Application Ref:	3/2026/0227			 Ribble Valley Borough Council www.ribblevalley.gov.uk
Date Inspected:	28/04/2026	Site Notice:	28/04/2026	
Officer:	MC			
DELEGATED ITEM FILE REPORT:				REFUSAL

Development Description:	Retrospective application for the raising of eastern wing roof and 'covering' of the former yard/pens and alterations to fenestration. Proposed change of use from agricultural to holiday let.
Site Address/Location:	Lodge at Winkley Hall, Whalley Road, Hurst Green, BB7 9PN

drawing number  
**PL.01**

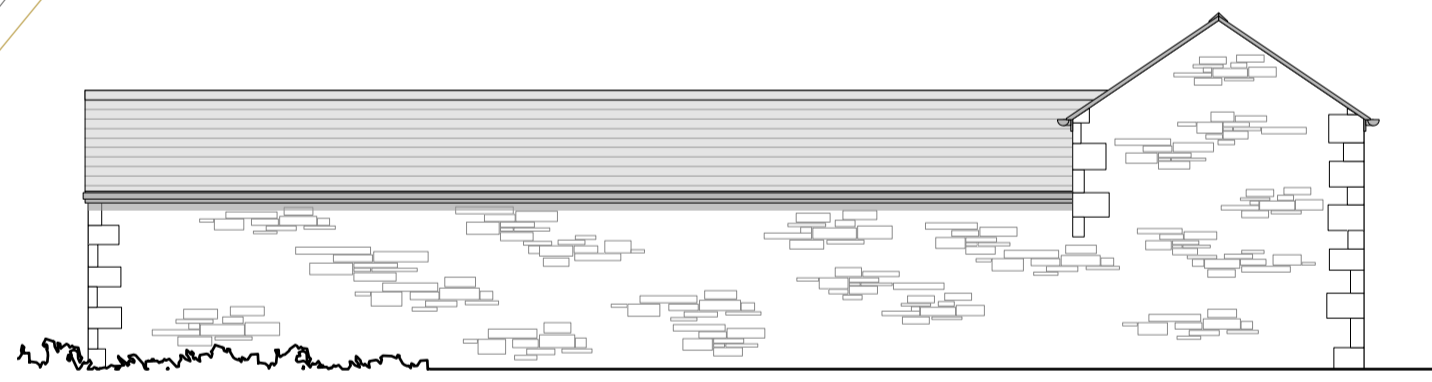
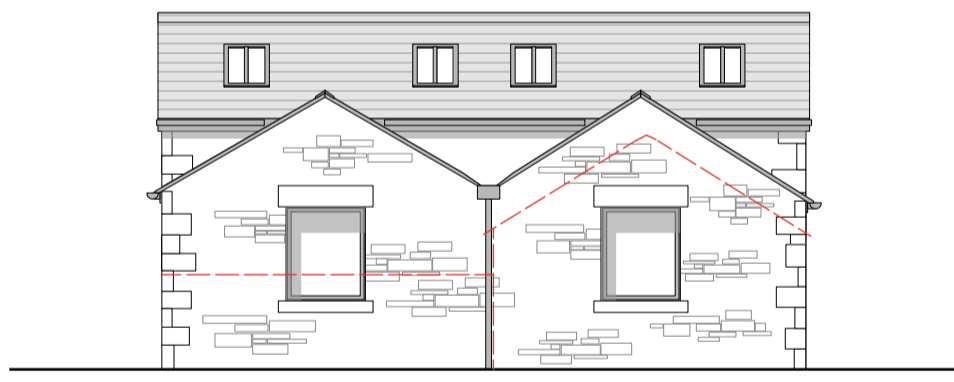
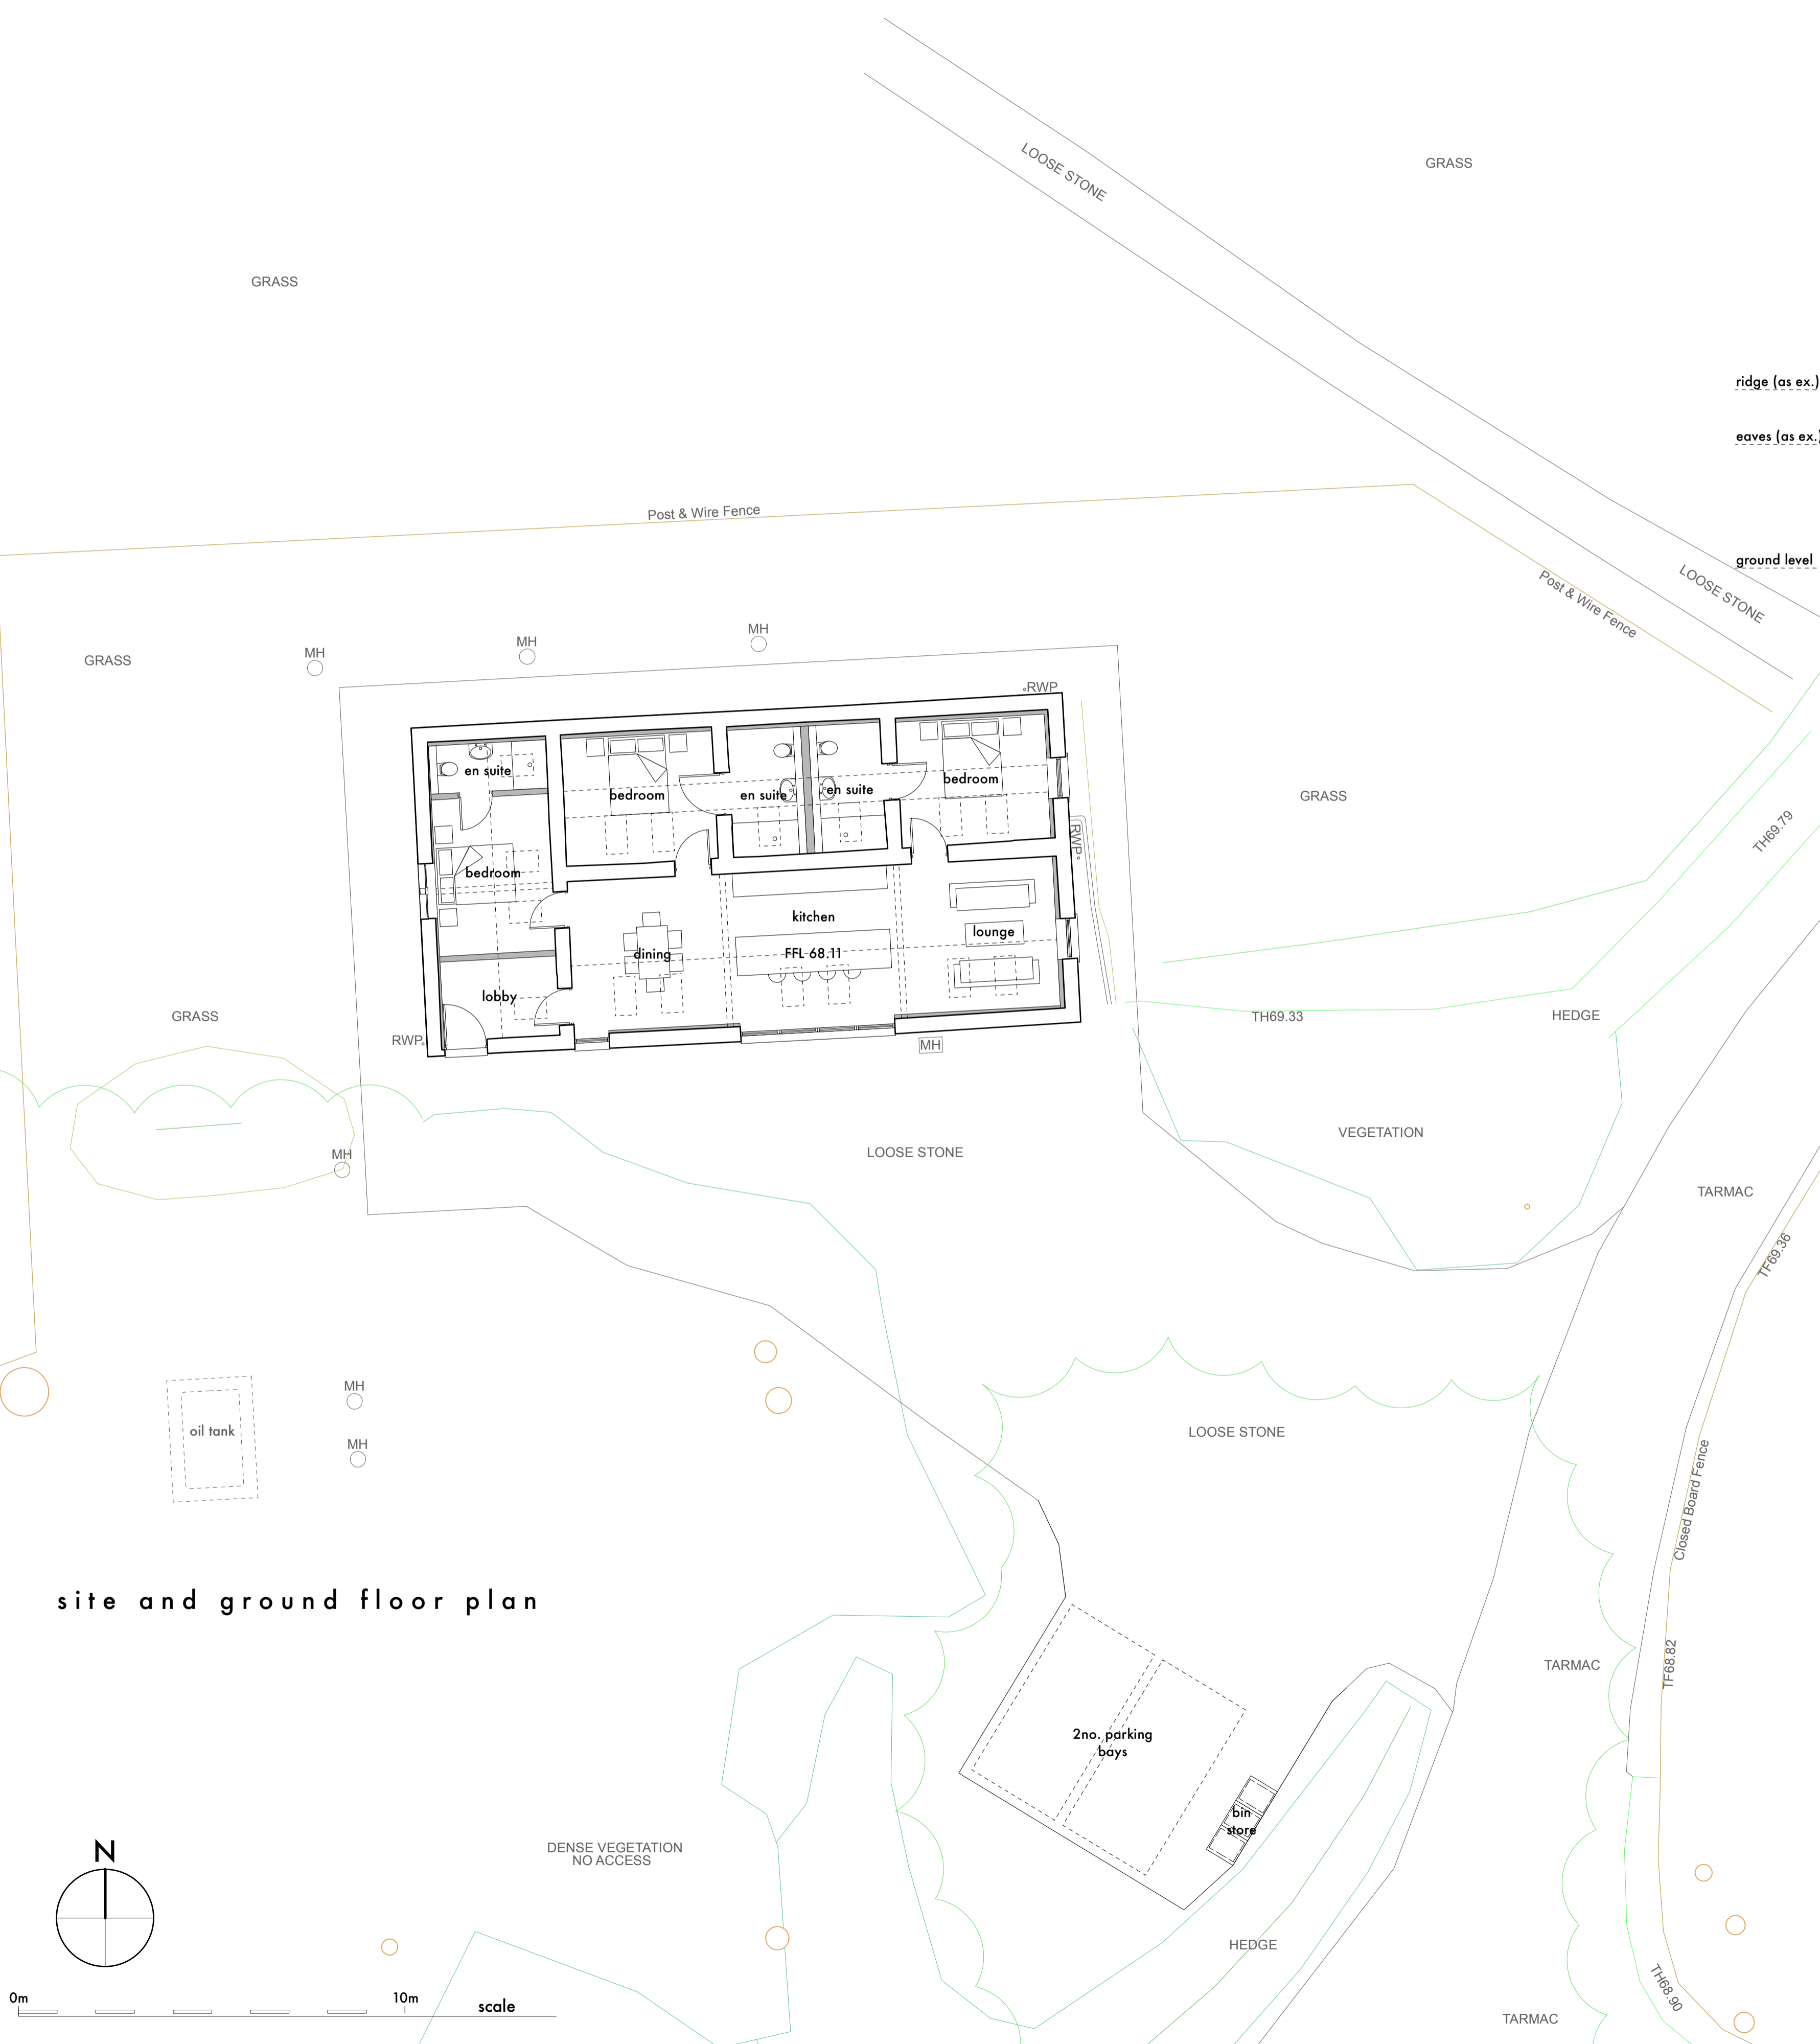
Firstly, it is noted that the chimney has been removed and the roof of the taller part of the building replaced with slates. These changes alone are not considered detrimental to the character and appearance of the area. The pre-existing survey plans and the Council's photographic records indicate that the front part of the building comprised three concrete yard 'pens' with a stone wall surrounding each 'pen'. This has been replaced with a new outrigger with a gable roof, similar in size and scale to the rear outrigger (which has been raised in height). When viewed from the east of the property, these outriggers have a dual pitched roof but are of differing widths and appear slightly at odds and detract from the character of the former agricultural building.

The retrospective works have also removed the existing timber, stable door to the south elevation and the proposal seeks to replace this with a powder coated aluminium door. Also, to the south elevation, two sections of timber boarding are proposed which are already in situ and the existing central opening would see the insertion of aluminium patio doors. Whilst timber boarding is not an uncommon material used on the flank walls of agricultural building, it appears at odds with the stone walls, given that the timber boarding would only extend from mid-way to the eaves of the wall and that it is single storey. In addition to this, the insertion of 10 new rooflights and the proposed new windows/doors would appear overly modern/domestic in appearance and do not reflect the randomised sequence of openings typically seen on agricultural buildings.

02:	The extent of alterations and extensions to the existing building, in particular the increase in height of an existing outrigger and introduction of a second outrigger, together with the new additional window/door openings and introduction of domestic curtilage and paraphernalia, would detract from the former agricultural building and result in an urbanising impact on the rural character of the site and its immediate surrounds. As such the development would be contrary to Paragraph 135 of the NPPF and Policies DMG1, DMG2 and DMB3 of the Ribble Valley Core Strategy.
